SUBMISSION: NSW Department of Planning & Environment SSI 7485

WestConnex M4-M5 Link – Modification 2 The Crescent overpass

Figure 4-4 Elevation: Indicative view of The Crescent overpass

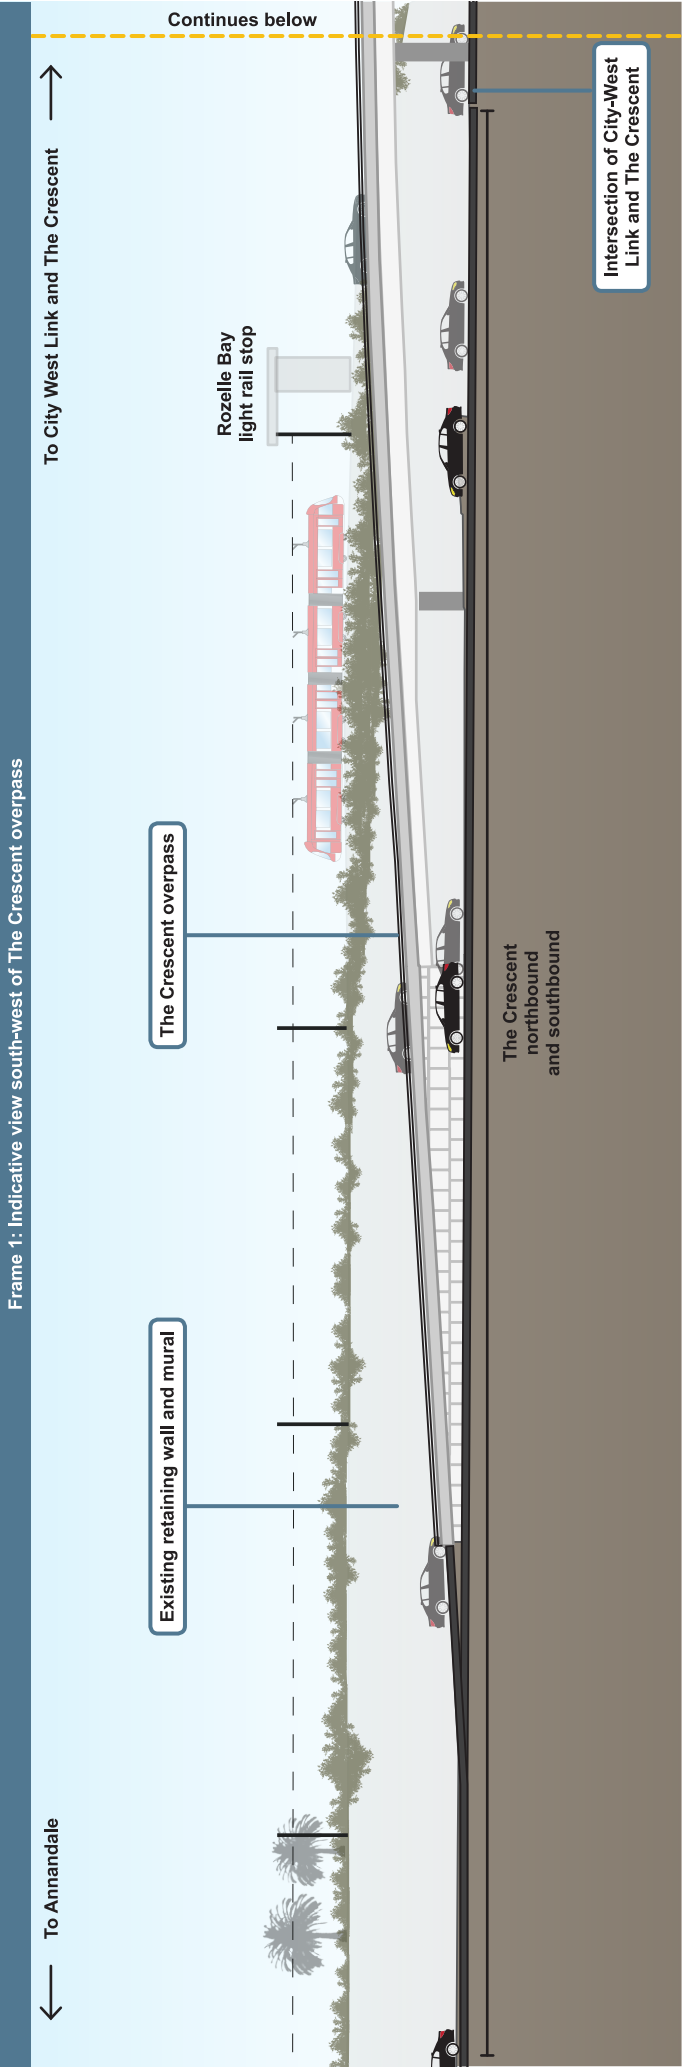
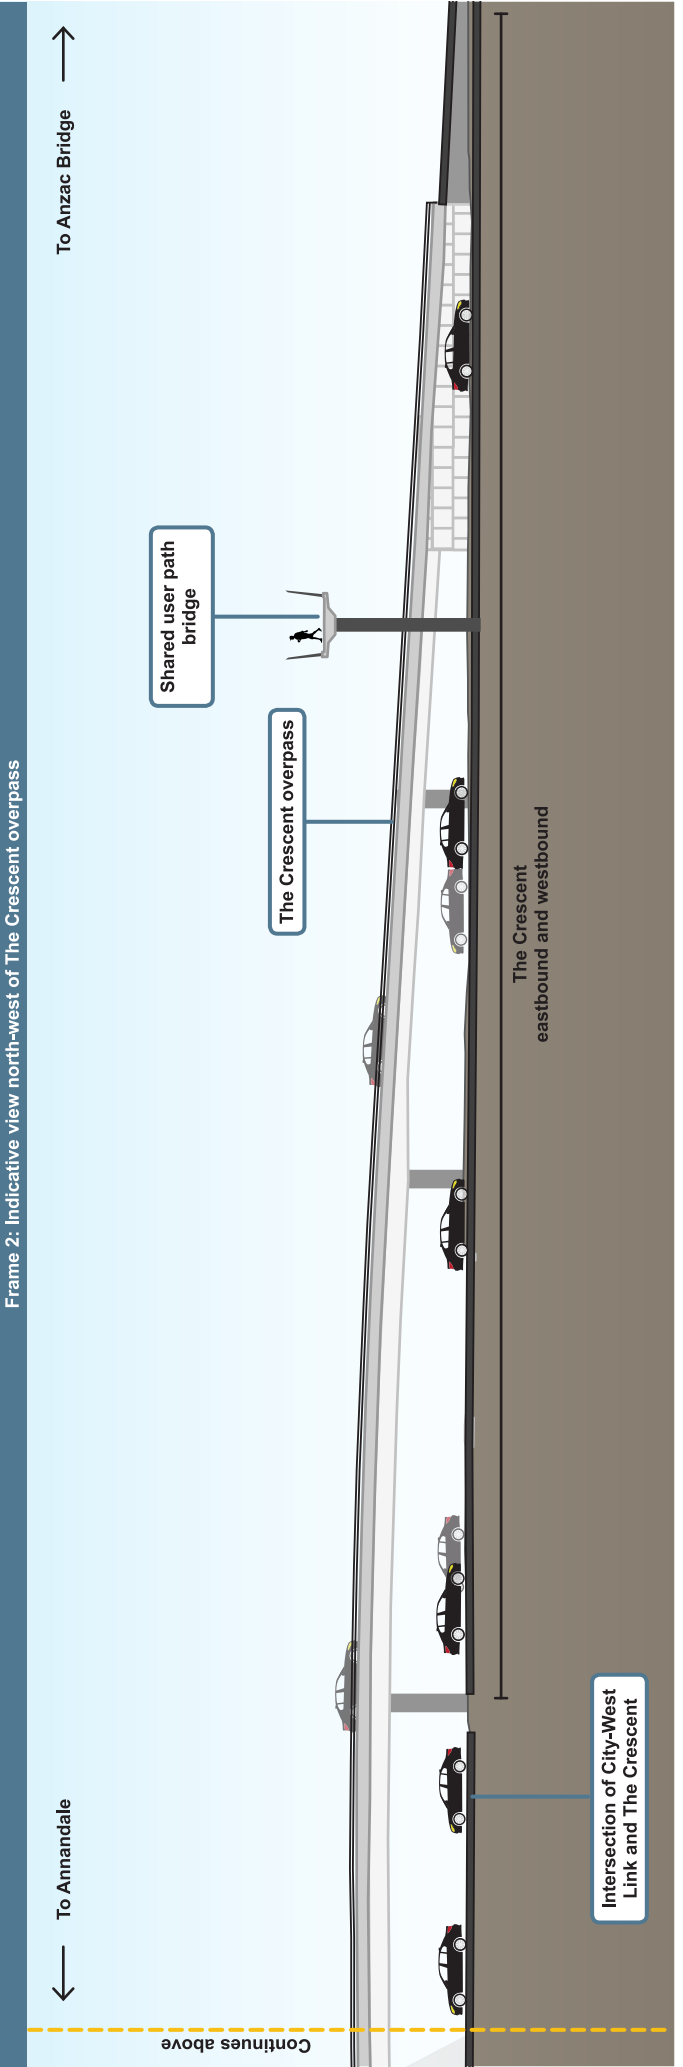
This modification will impose hugely on the local landscape in the inner west. A new elevated overpass is completely at odds with local development standards and will have a significant negative visual impact on Annandale and its surrounds.

These changes will result in a lack of visibility of the foreshore, loss of amenity , physical and social alienation. The overpass will be a visual blight - blocking sight lines to the waterfront and will have a huge impact on the community's relationship with the foreshore.

The overpass will also obstruct Rodney Monk's heritage mural which decorates the northern side of the light rail viaduct along The Crescent. That mural was commissioned by the Leichhardt Council in 1980 and inspired by political and social movements in the inner west.

Figure 4-5 The Crescent/Johnston Street/Chapman Road intersection

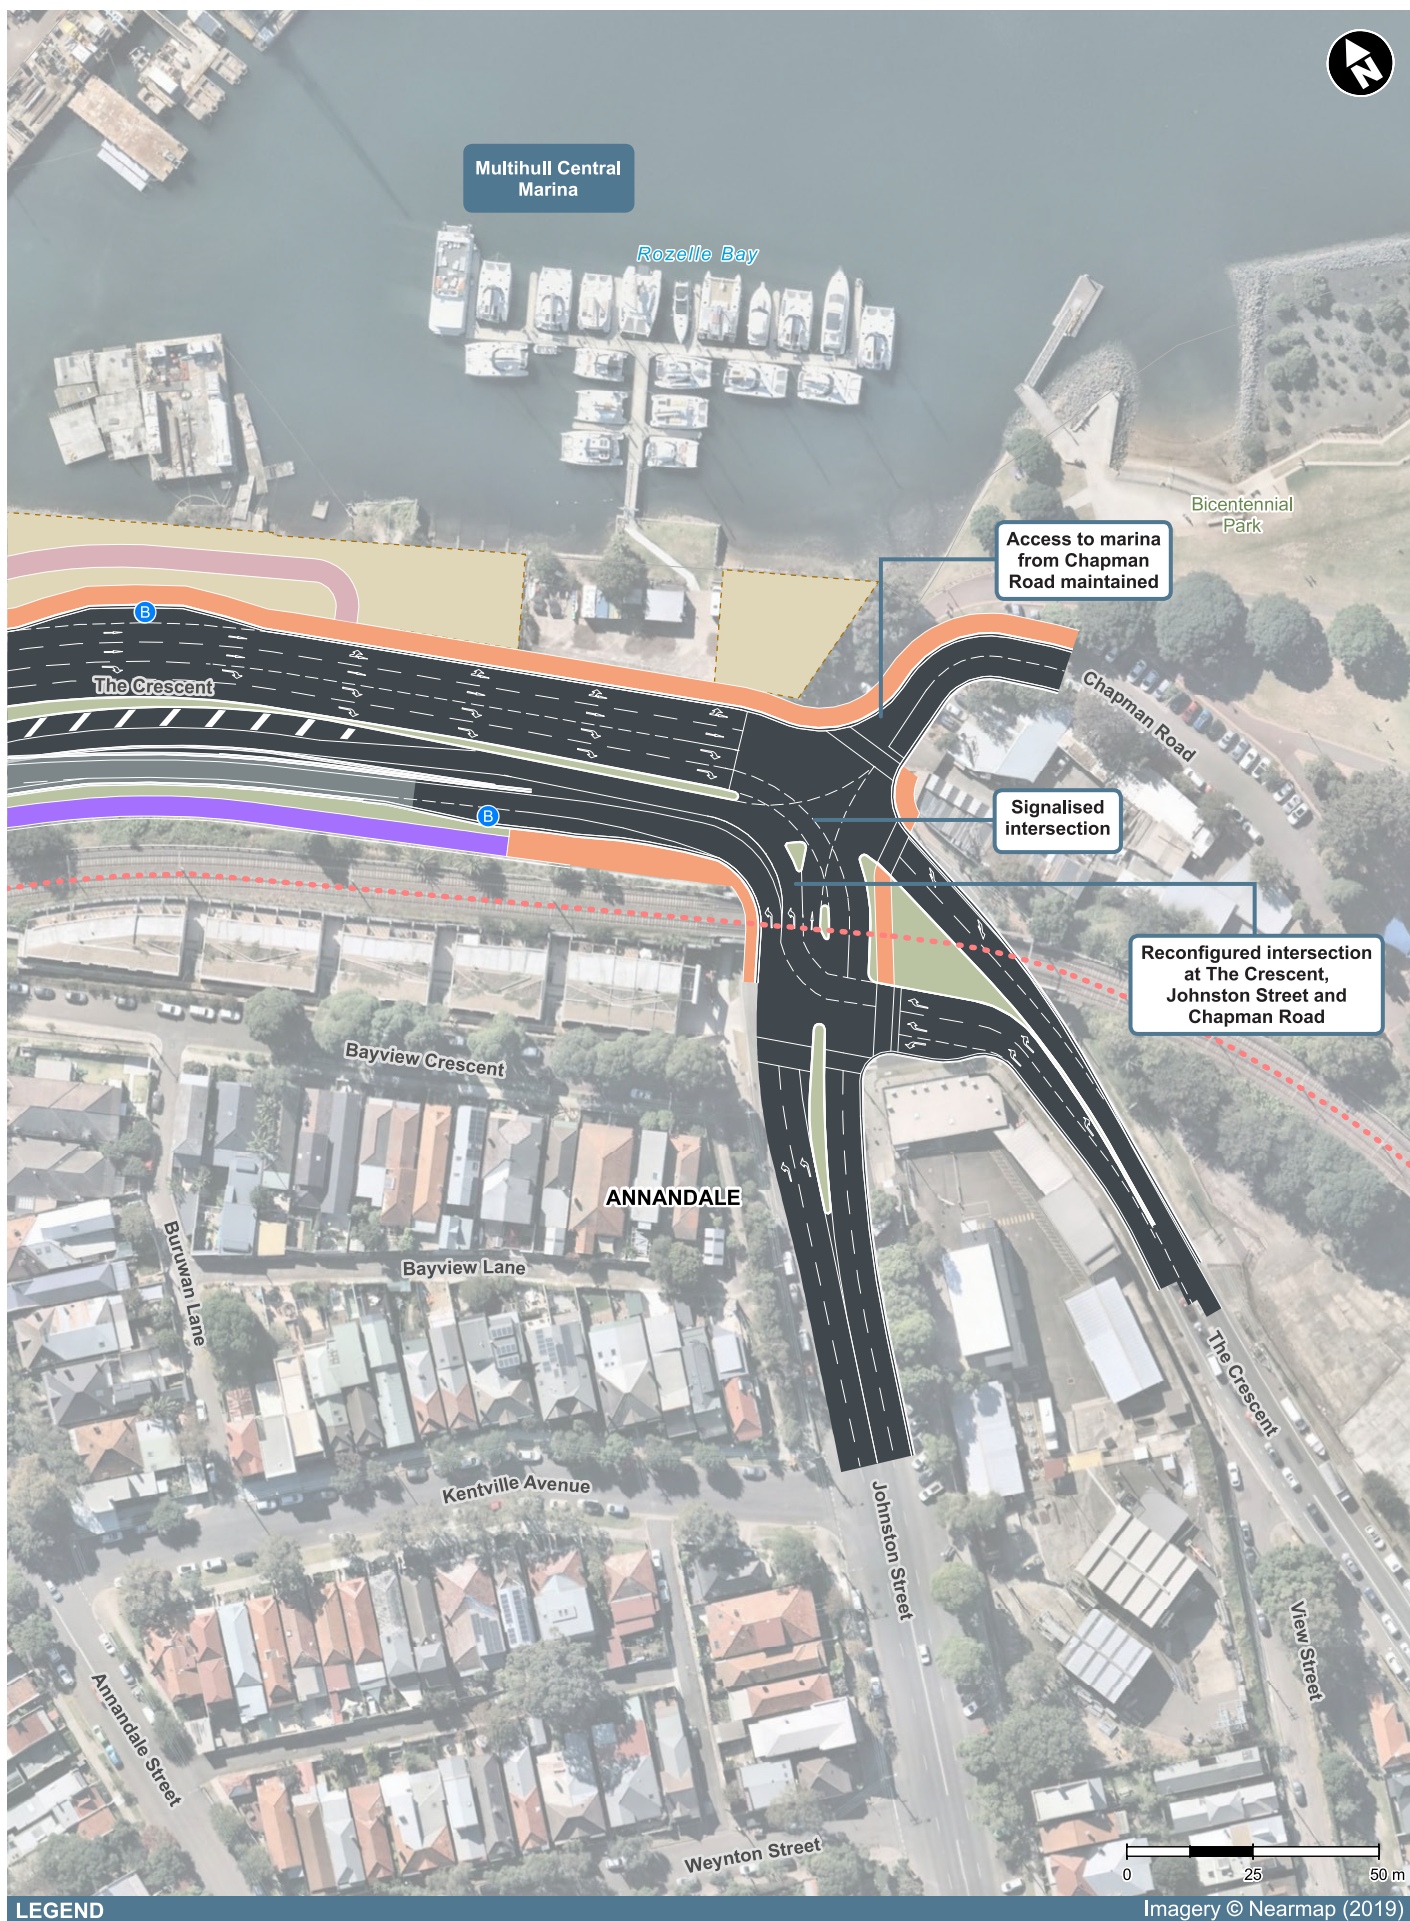
Pedestrians walking from the Western side of Johnston Street will have to use four pedestrian crossings to reach Bicentennial Park. It will significantly reduce safety and increase the risk for pedestrians and cyclists with changed direct access across the Crescent to Bicentennial Park.

This pedestrian arrangement should be modified to allow pedestrians to cross directly from Johnston Street to the Park via The Crescent.

This modification would remove the option to turn right out of Johnston Street into the Crescent which will increase traffic through local streets including Piper Street and Booth Street. These changed conditions will mean increased noise and emissions for residents in Annandale. It is time we learnt from the consequences of major toll road construction that projects like this increase air pollution, encourage more car use, fleece road users with exorbitant tolls and eventually fill the increased road capacity they create.

Changed traffic routes (No RH turn north) on Johnston Street will make it difficult for people wanting access to the Tramsheds. It will increase cars on local roads. It will also directly affect us and our friends since this is the main route between our homes.

Figure 4-6 Elevation: Indicative view of Rozelle Rail Yards Pedestrian and Cycling Green Link

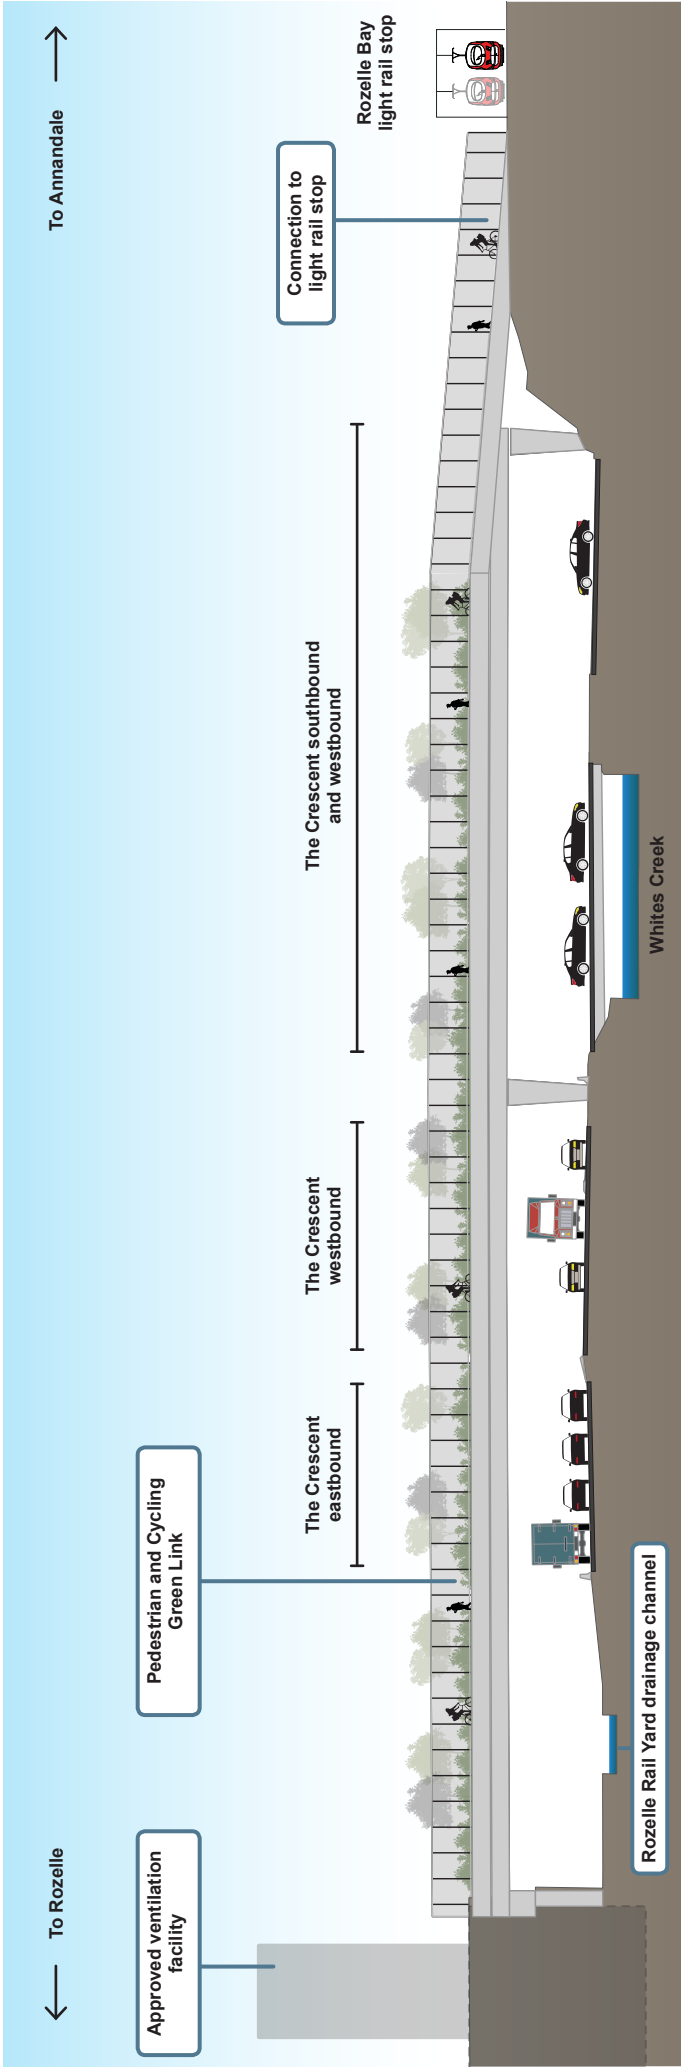
This modification would abandon one of the centrepieces of the original design: a pedestrian and cycling green link to connect the Rozelle Goods Yard to Bicentennial Park.

Relocating this green link to the west of the intersection of The Crescent and City West Link ignores the original conditions of consent given for this project and puts the needs of motorists ahead of pedestrians and cyclists. The proposed pedestrian bridge further north up the City West Link creates an unnecessarily long walk for pedestrians and an unnecessarily high climb of 5+ metres. RMS and the contractors should reconsider other design options for a continuous green link from Rozelle Goods Yard, across the City West Link into Jubilee Park, including a link to Annandale and the Rozelle Bay light rail stop.
